WRITTEN REPRESENTATION ON BEHALF OF NORFOLK WILDLIFE TRUST

Application by East Pye Solar Limited for the East Pye Solar Development Consent Order

Planning Inspectorate Reference: EN0110014

**Figure 8.4 - Irreplaceable Habitats within 2km**  
 Index Sheet  
 Revision A

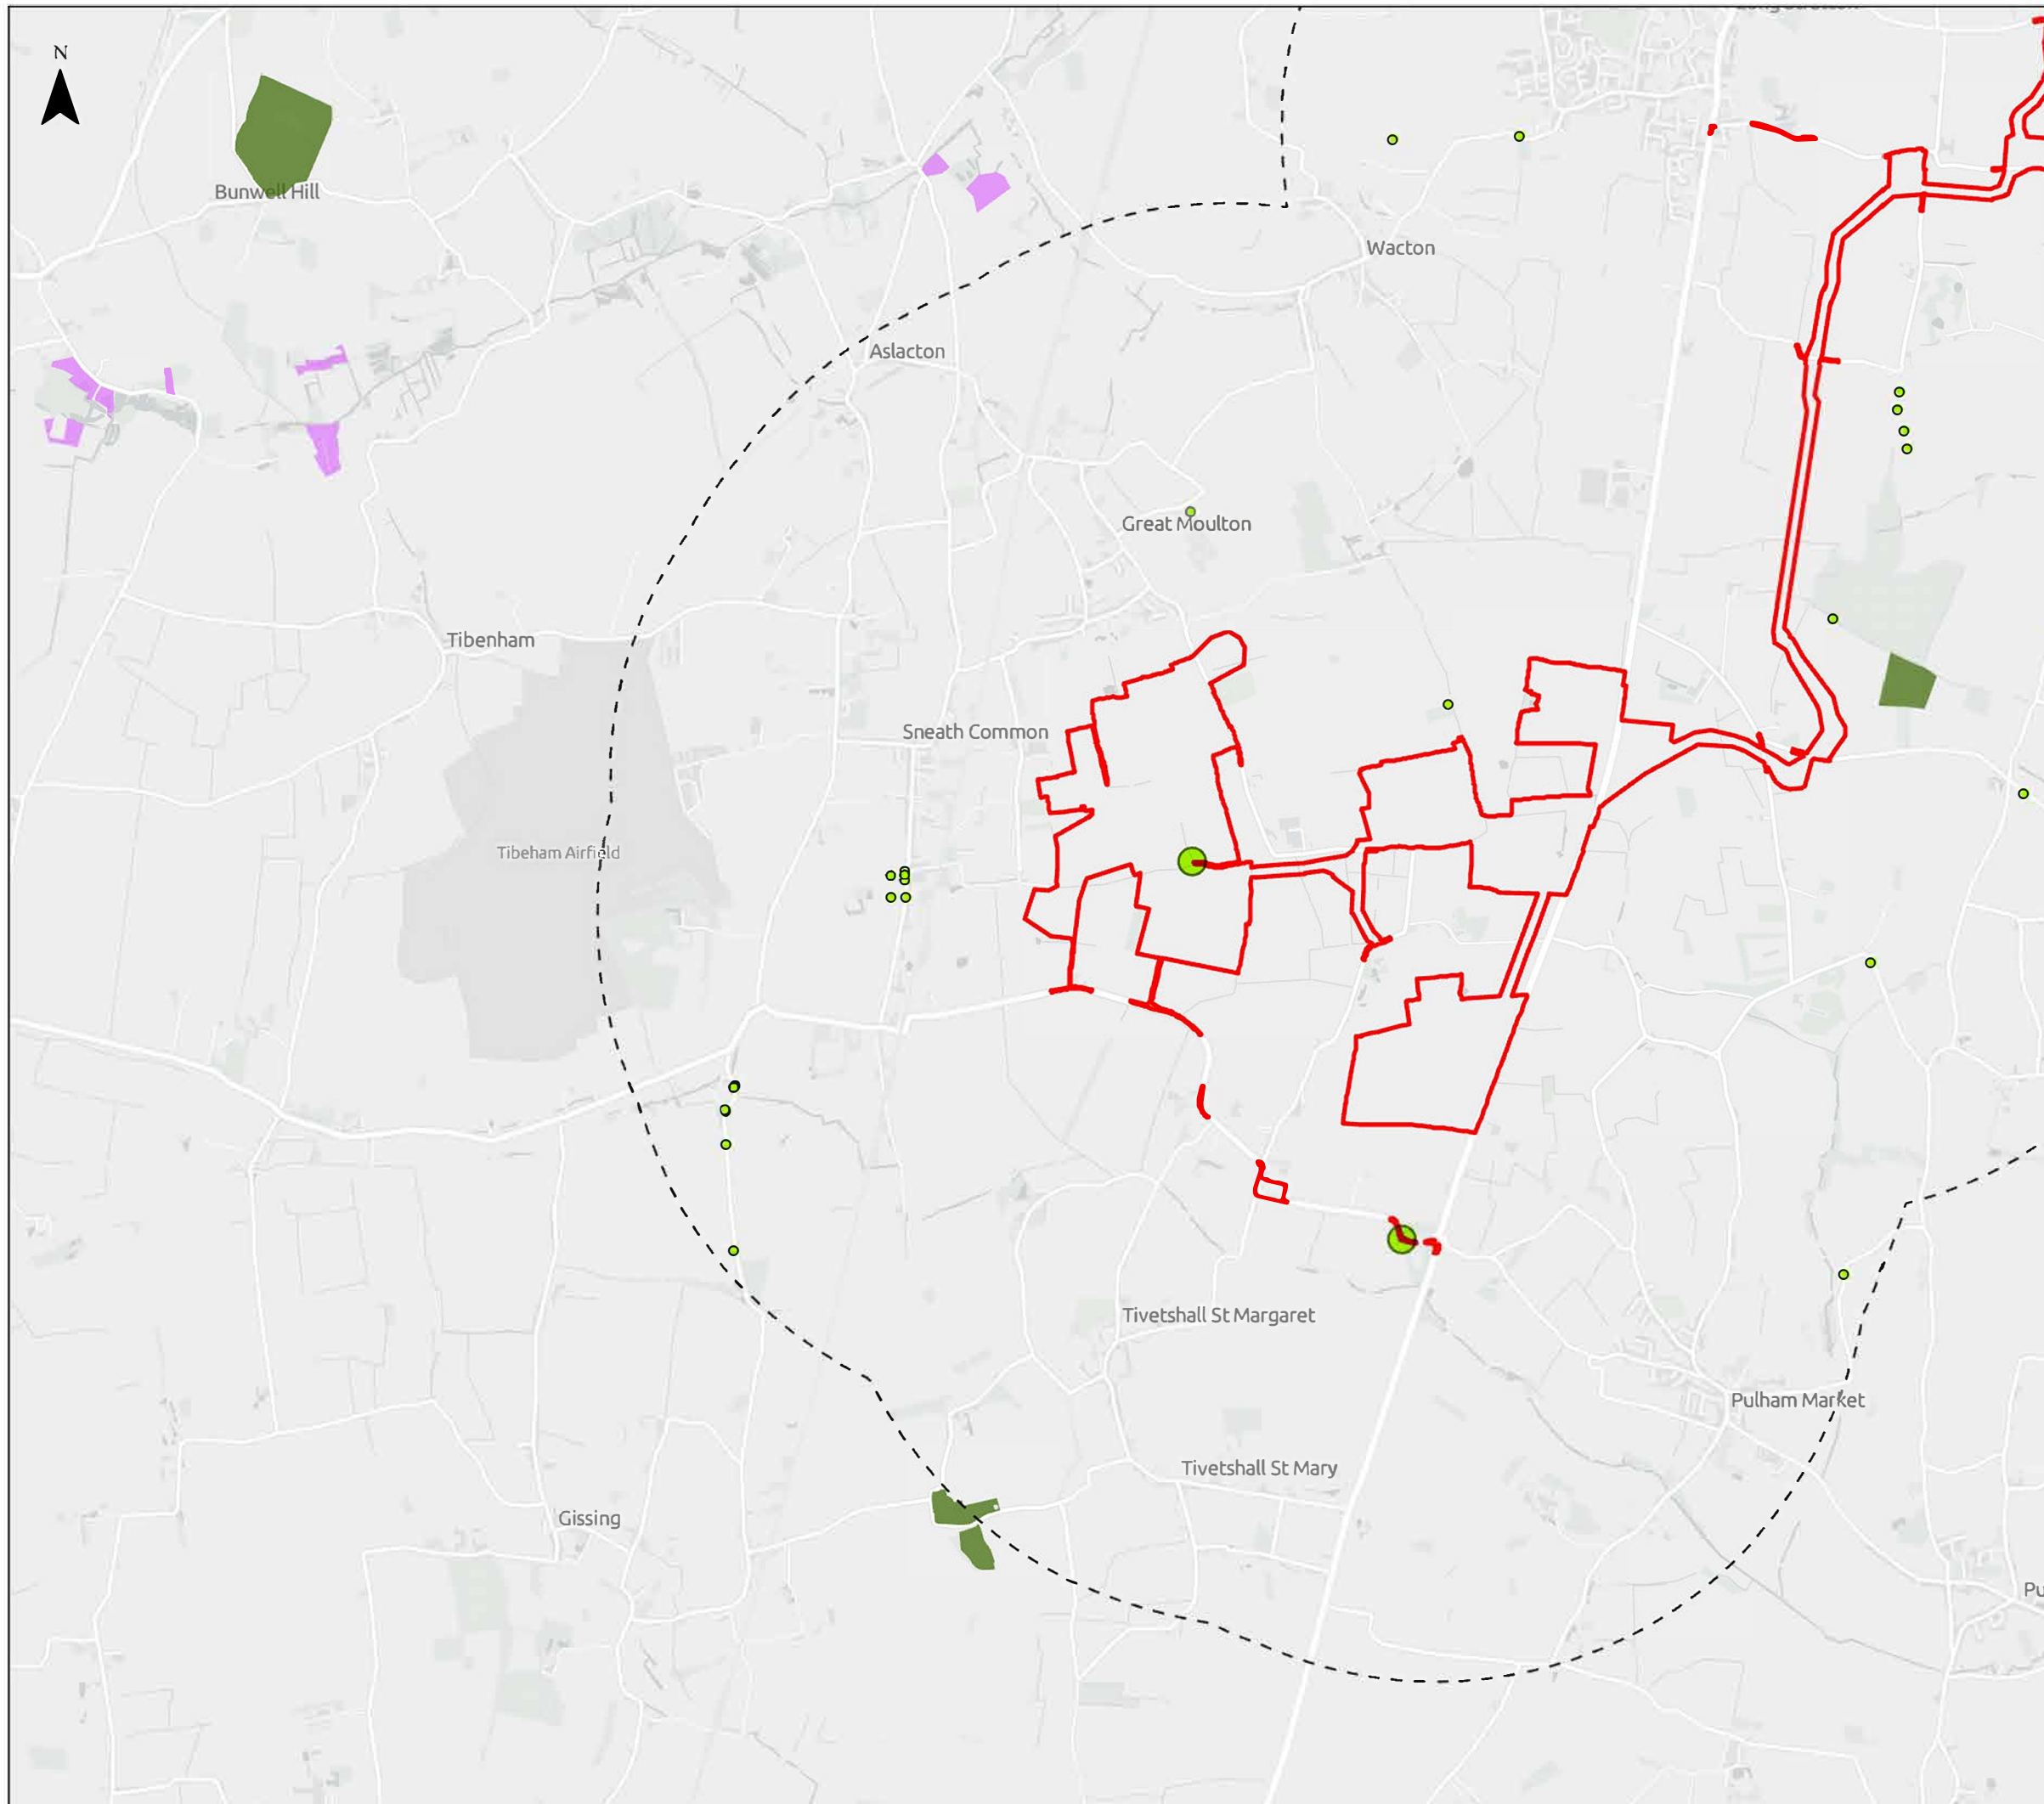
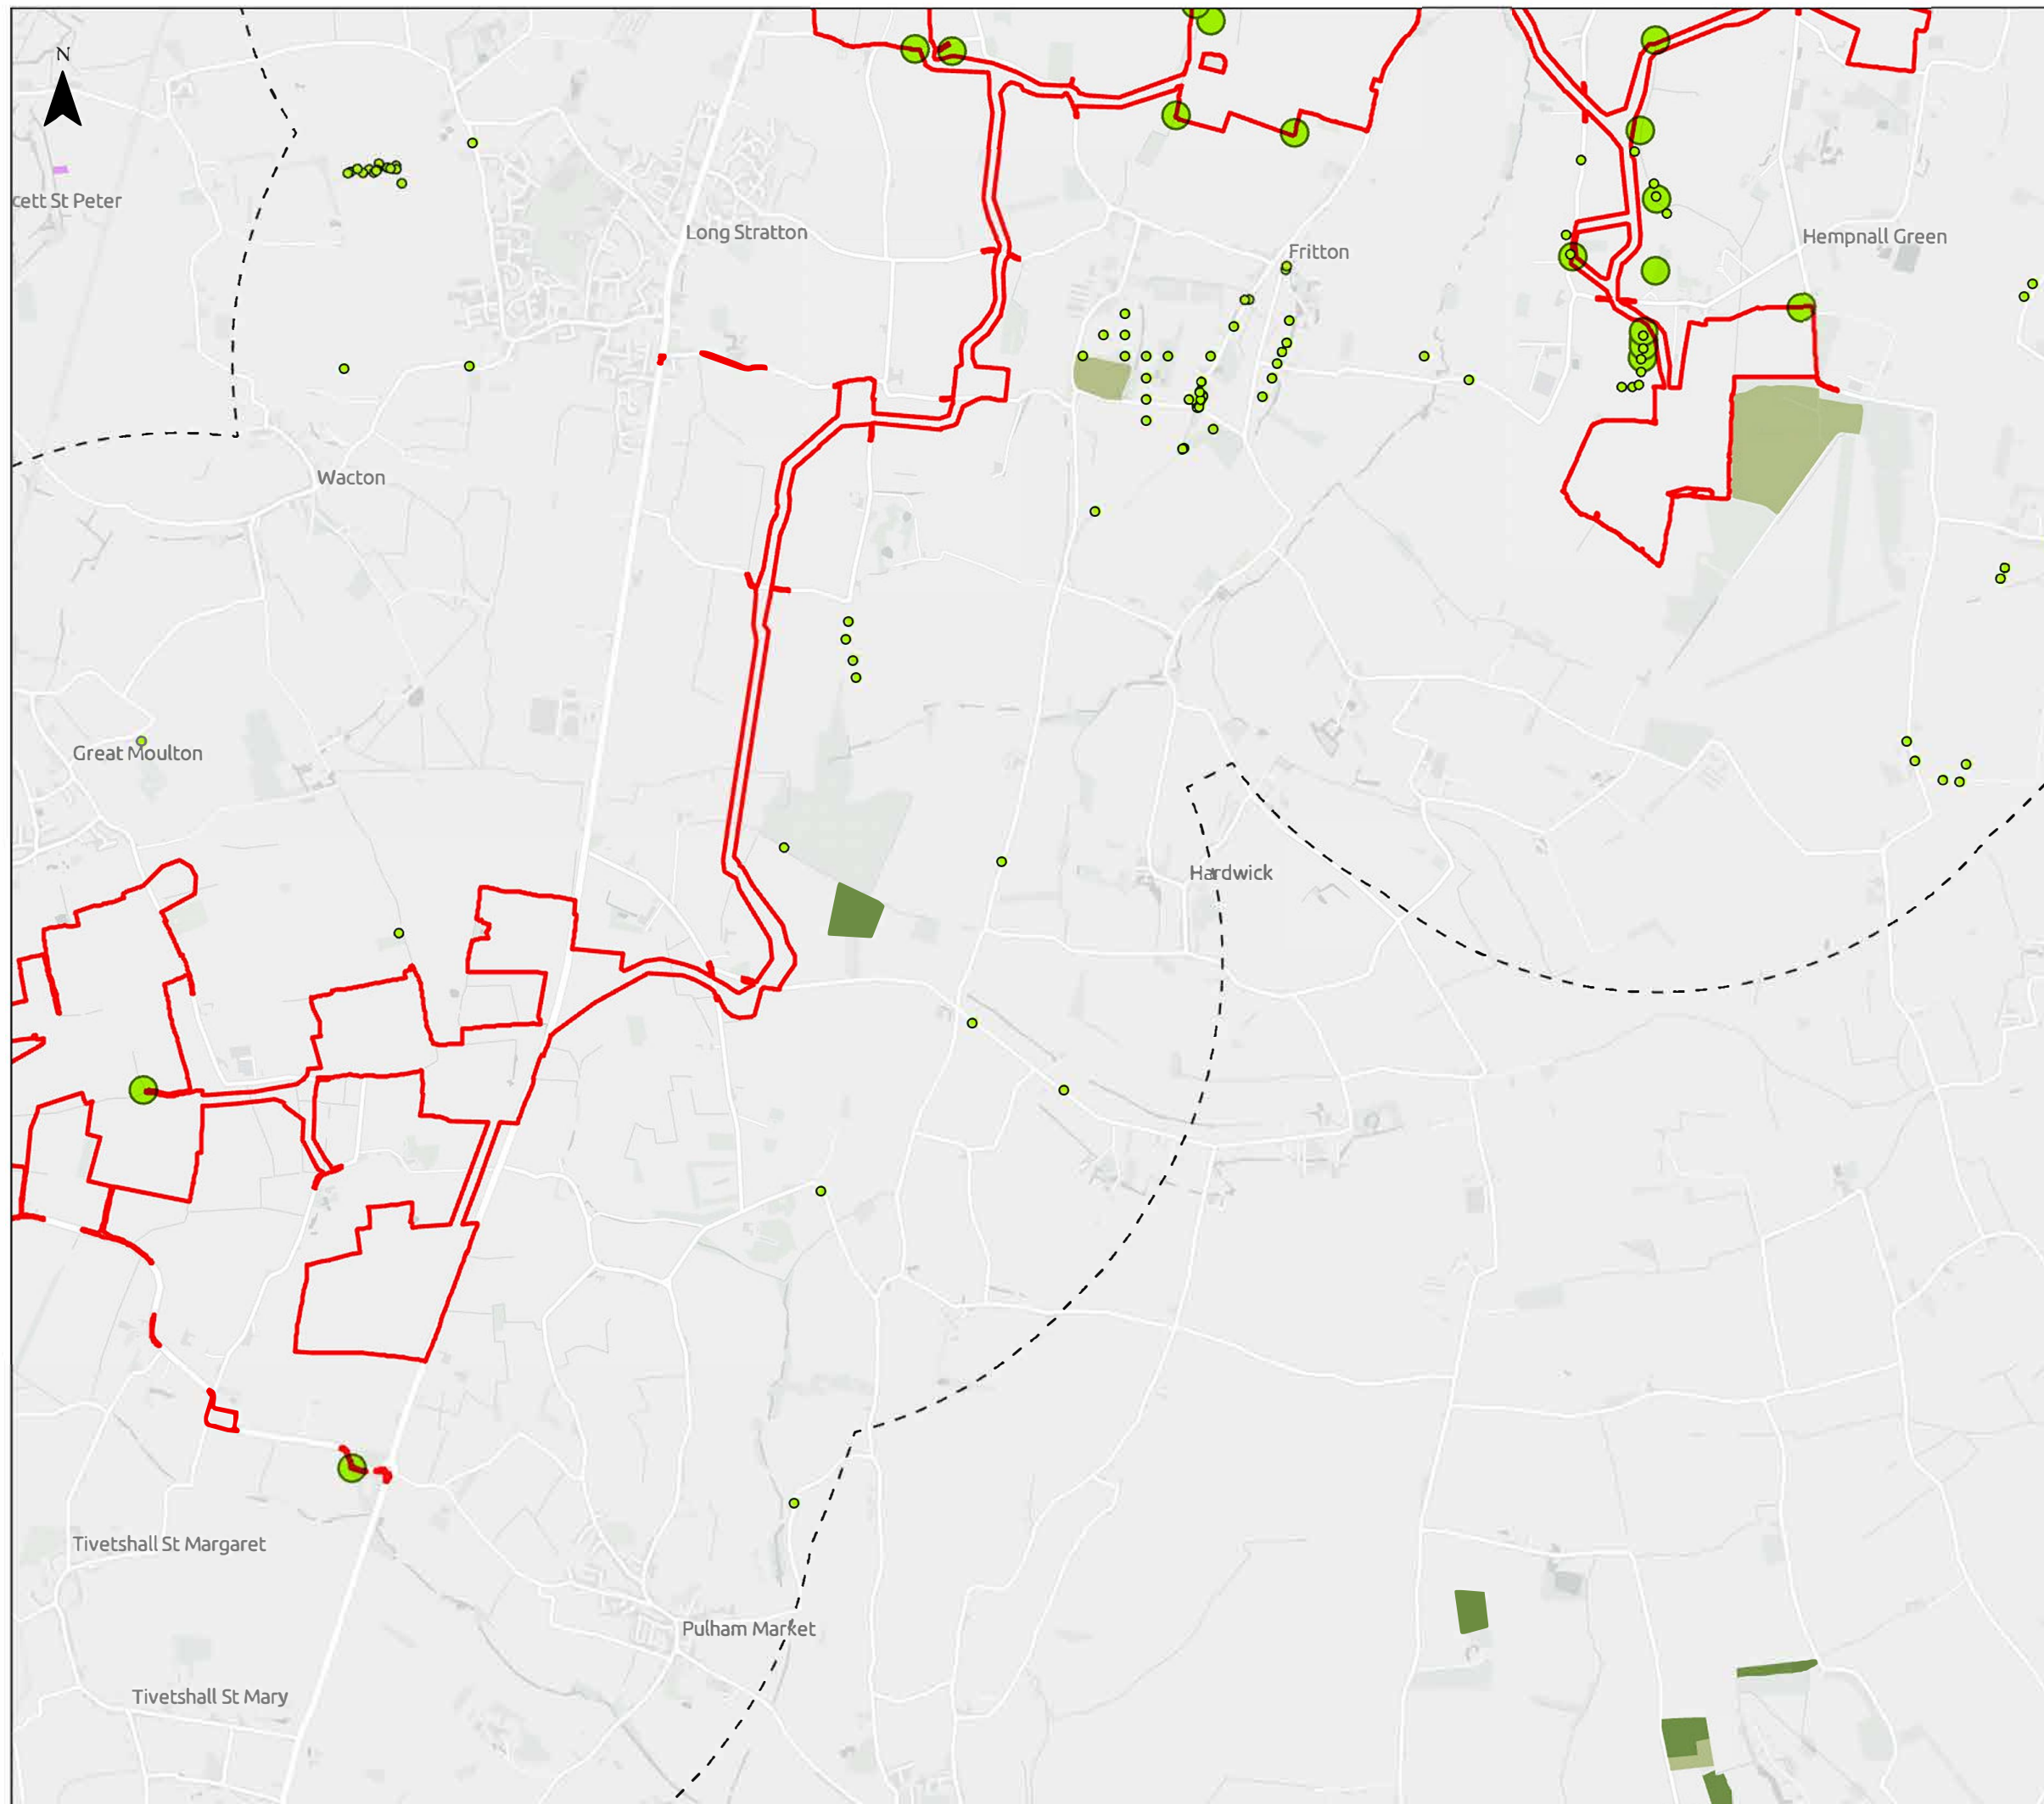
- This includes an area of lowland fen habitat within the cable route corridor. Lowland fen is an irreplaceable habitat and is highly sensitive to hydrological change, groundwater disturbance, compaction and pollution. It is stated that Horizontal Directional Drilling (HDD) will be used and the Outline CEMP includes design measures to reduce impacts through run-off control, pollution prevention and dust control during construction and specifies Stand-off distances of 30m from the CWS, which we welcome.

- However, section 4.4 of the Outline Cable Route Construction Statement states that the technology used for the HDD will be determined by feasibility studies carried out at each crossing during the detailed design stage and in accordance with a method statement. The Outline CEMP also states that a Hydrogeological Risk Assessment will be undertaken, "if required". Although the applicant states that HDD will pass beneath the fen at a depth of at least 5m, insufficient evidence has been provided to demonstrate that construction activities will not affect groundwater conditions or the hydrological processes upon which the fen depends. The applicant has also stated that a Water Management Plan will form part of a detailed CEMP and will include details of pre-construction, construction, and post-construction water quality monitoring. Further details are required to allow proper scrutiny.

- The oCEMP confirms that the precise locations of HDD entry and exit points will only be determined at the detailed design stage. Without this information it is not possible to fully assess the ecological impacts or determine whether the proposed buffer distances are sufficient. HDD entry and exit locations should be identified prior to examination close.
